Appeal Decision

Appeal Ref: APP/R5510/W/20/3261429

3 Field Way, Ruislip HA4 7LT

- The appeal is made under section 78 of the Town and Country Planning Act 1990 against a refusal to grant planning permission.
- The appeal is made by Mr Peter Modrekeliidze against the decision of the Council of the London Borough of Hillingdon.
- The application Ref 59248/APP/2020/1381, dated 30 April 2020, was refused by notice dated 7 July 2020.
- The development proposed is a single storey detached garden building for ancillary use.

Title
Block Plan Rev.1

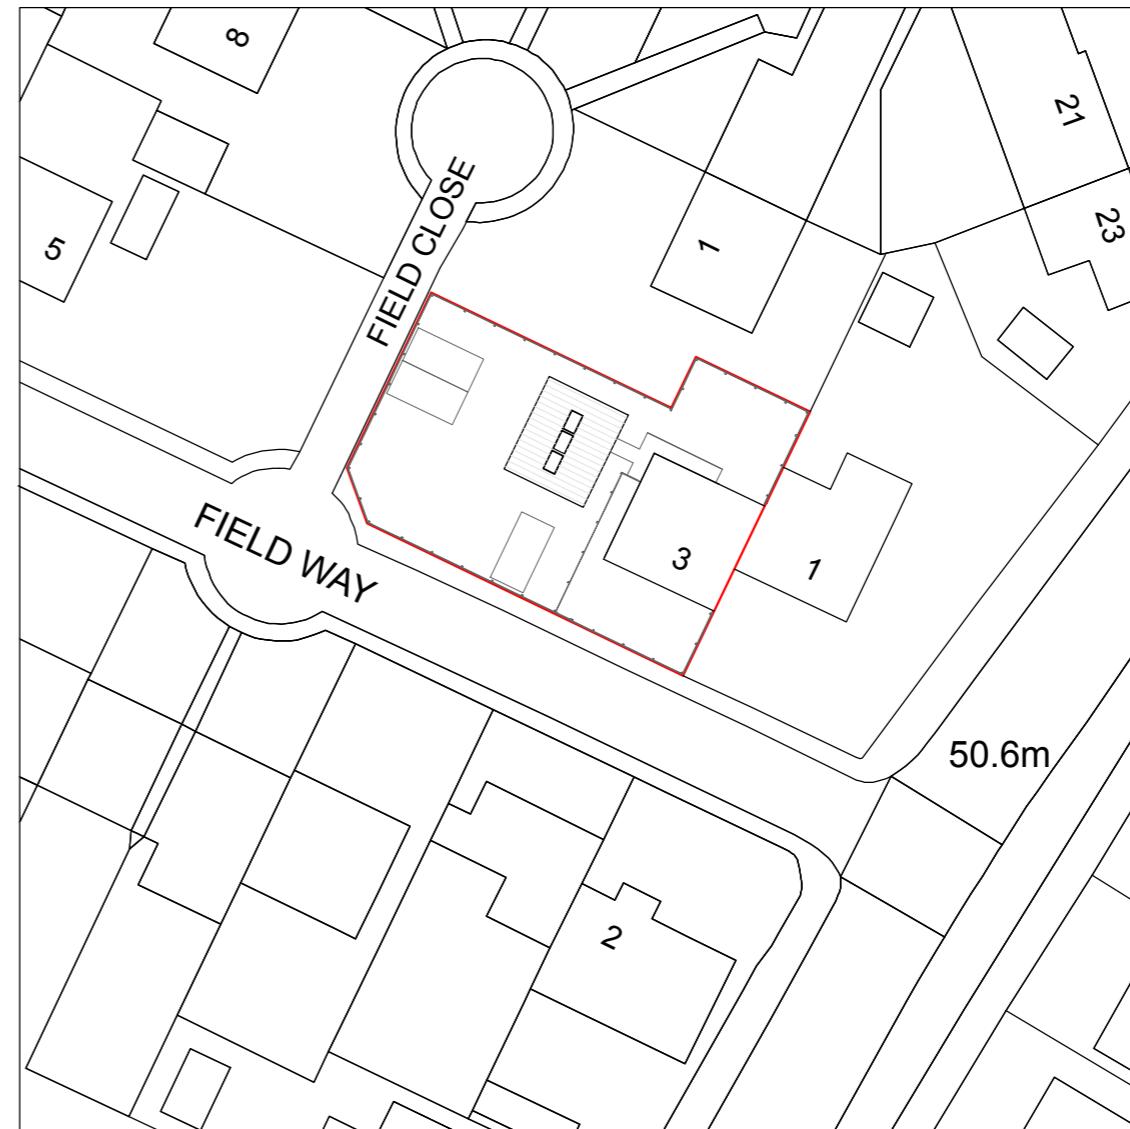
5. The proposal envisages a detached building of a flat-roofed and rectangular design sitting a short distance from the side wall of the existing building. Although the majority of the open area would remain, the proposal would considerably diminish the sense of openness at this corner site. In my judgement it would unacceptably erode the positive contribution that the site makes to the character and appearance of the area. I have noted that there is

a detached garage at No 5 in a similar position to what is proposed at the appeal site. However, the garage is considerably smaller in size and does not have the same degree of negative effect that would arise from the proposal. Therefore, I conclude on this issue that the proposal would have an unacceptable effect on the surrounding area, contrary to Policy DMH 6 of the Local Plan Part 2 Development Management Policies (DMP).
